Re: MMC Helipad Relocation and associated sound implications

Hi, Jean and Nell. I'd like to make some initial comments, more or less in draft version, since I don't know the exact timeline for review of the revised Sound Management Plan. I would be very happy to have an informal discussion about these comments before submitting a final version.

Appendix 6: 2017 Sound Study Measurement Locations

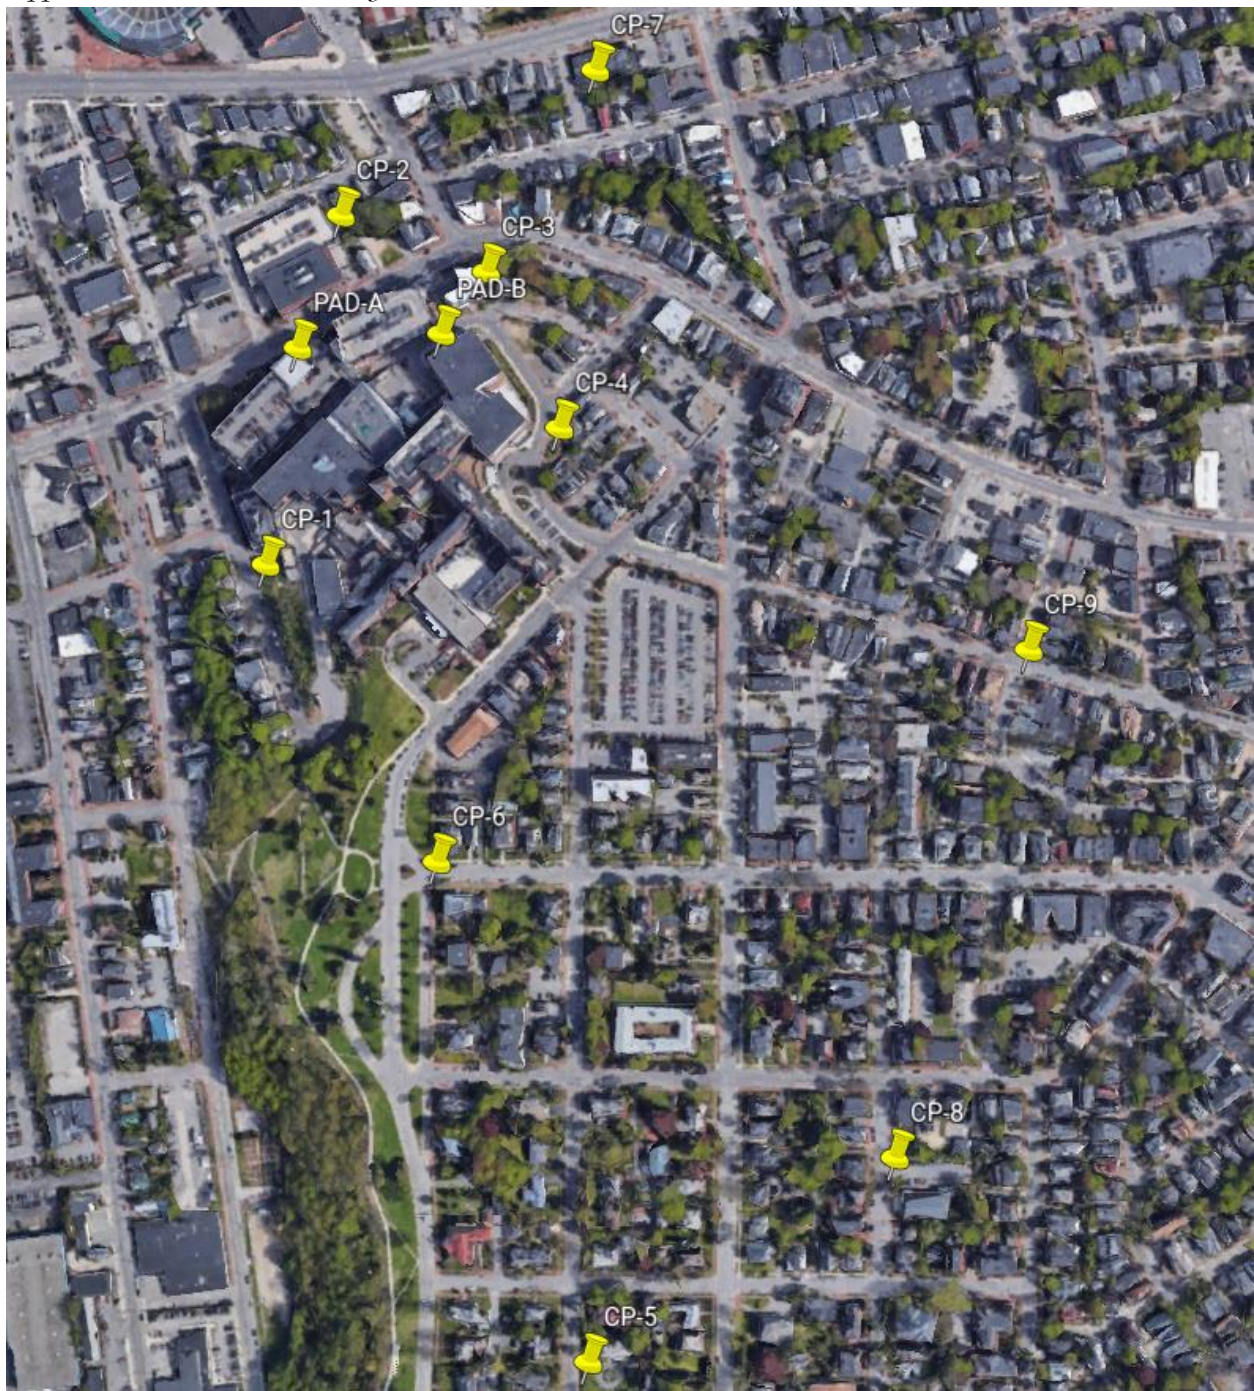
I believe additional locations are needed. I see a need for a line-of-sight measurement location in-between the radiuses of CP-4 and CP-6 and -9. The first represents a potential worst case location, which is useful, but CP-6 will have some building shielding, and CP-9 is significantly distant. Some middle-distance readings are needed, since this region of the West End is one that will likely experience a significantly changed sound pattern. With the loss of the sound-mitigation through building blockage that exists now, and a greater height, yielding line-of-sight and -sound to hundreds more homes than the previous location, a significantly changed soundscape seems almost inevitable.
